Nicole Heliwell
Kirklees Council

Our ref: L01607256
Your ref: 2026/65/90398/E

**T&CP (Development Management Procedure) (England) Order 2015
& Planning (Listed Buildings & Conservation Areas) Regulations 1990**

Application No. 2026/65/90398/E

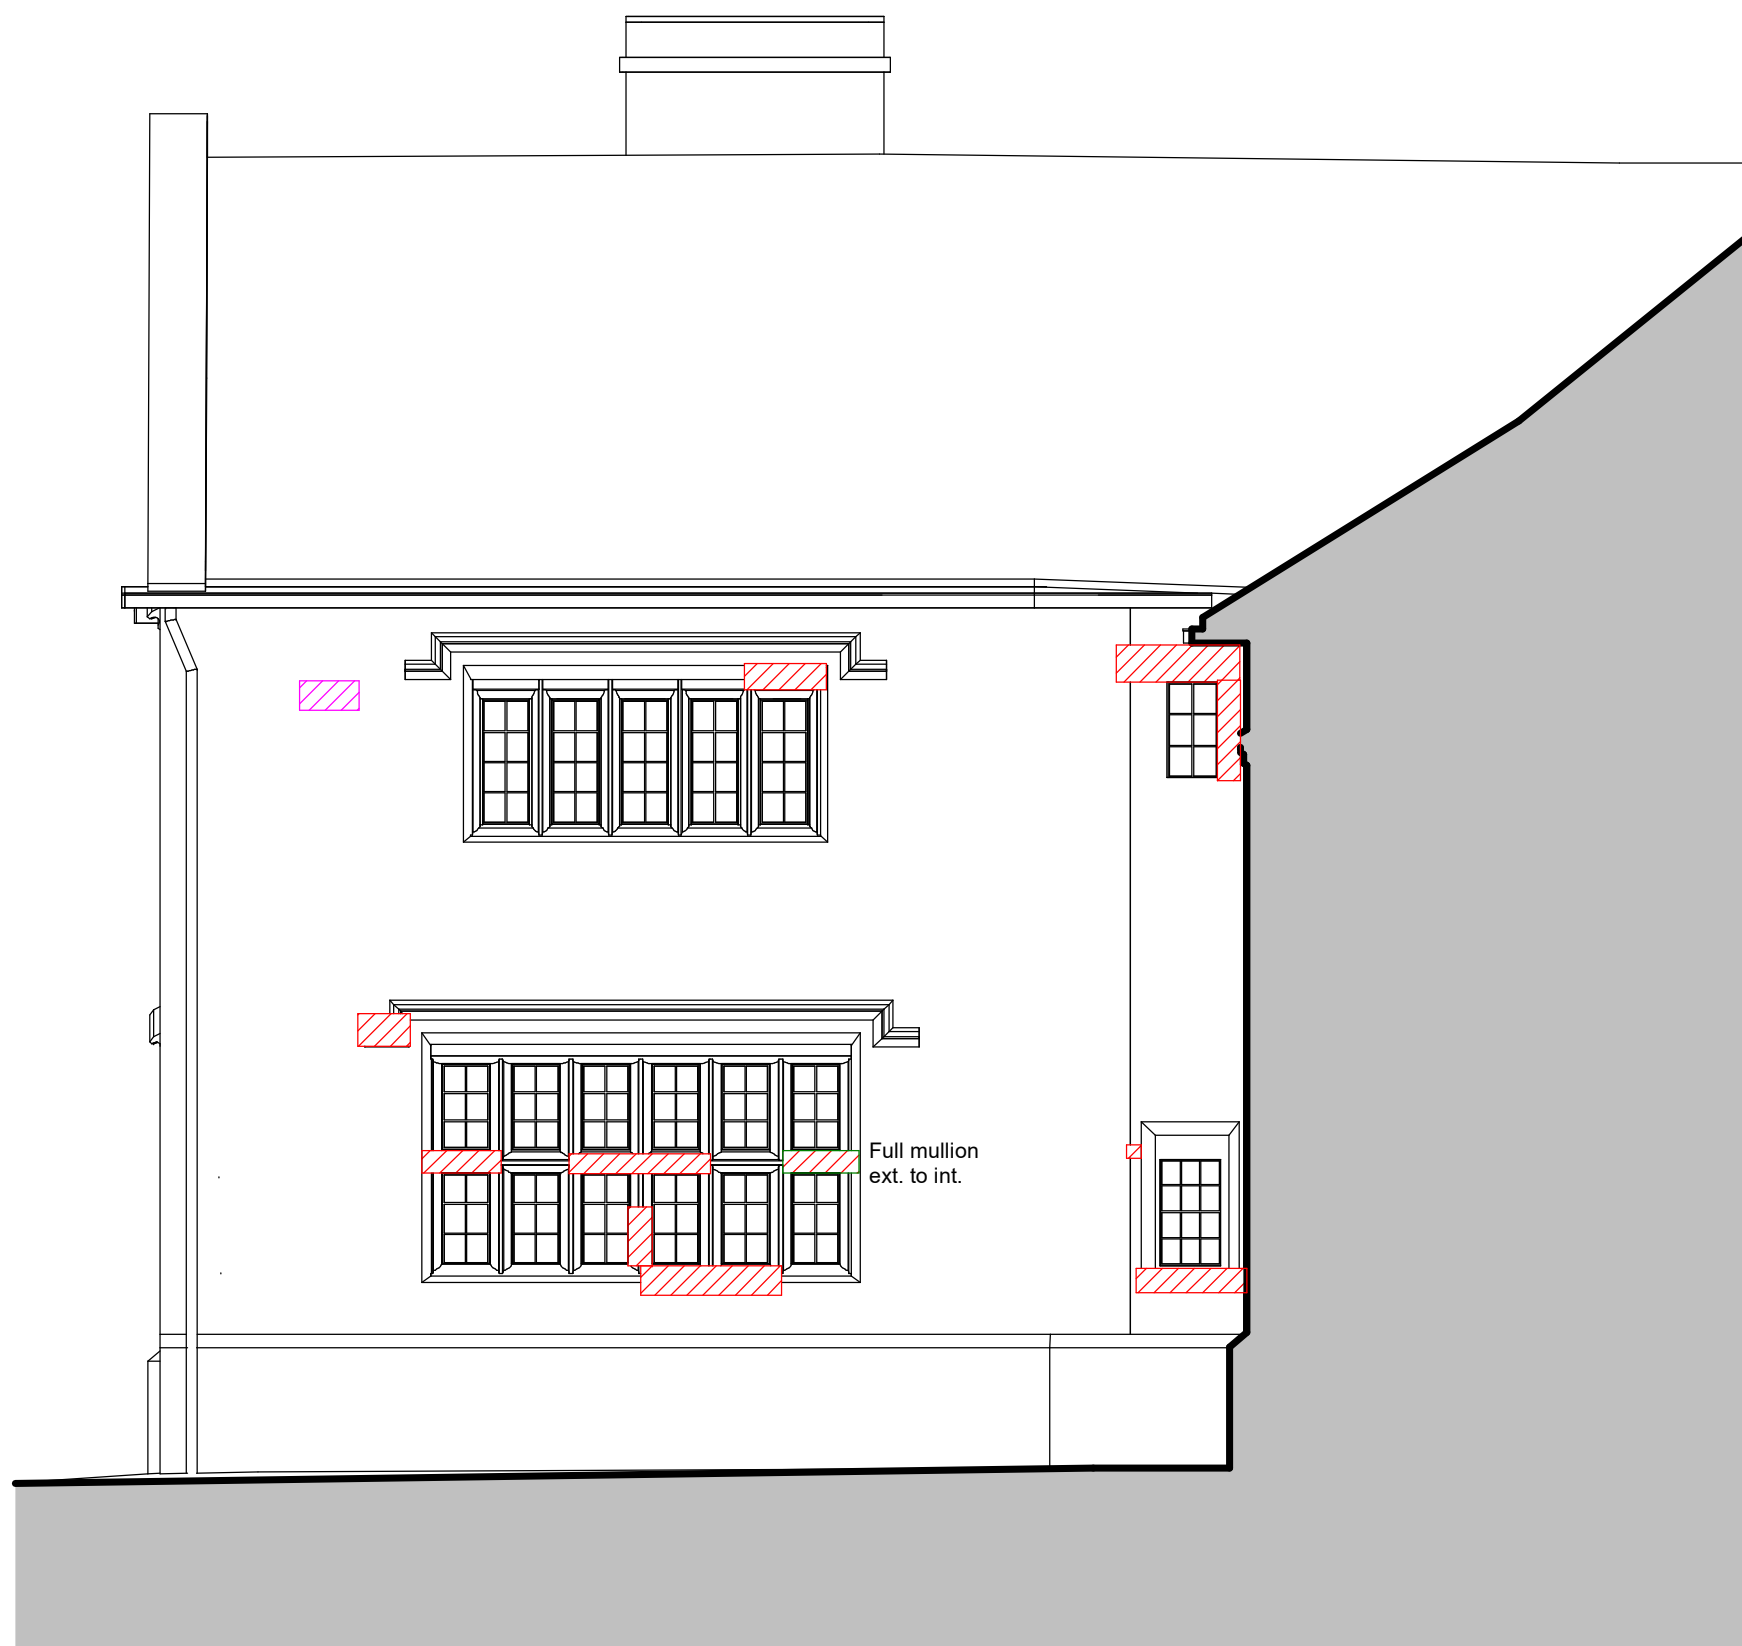
Largely the repairs to stone will have a small visual impact due to newly quarried and worked stone to be used to replace the historic stone. However, this will enable the building fabric to be more resistant to further decay and so this is largely balanced out and is proposed to use stone from the original quarry sources.
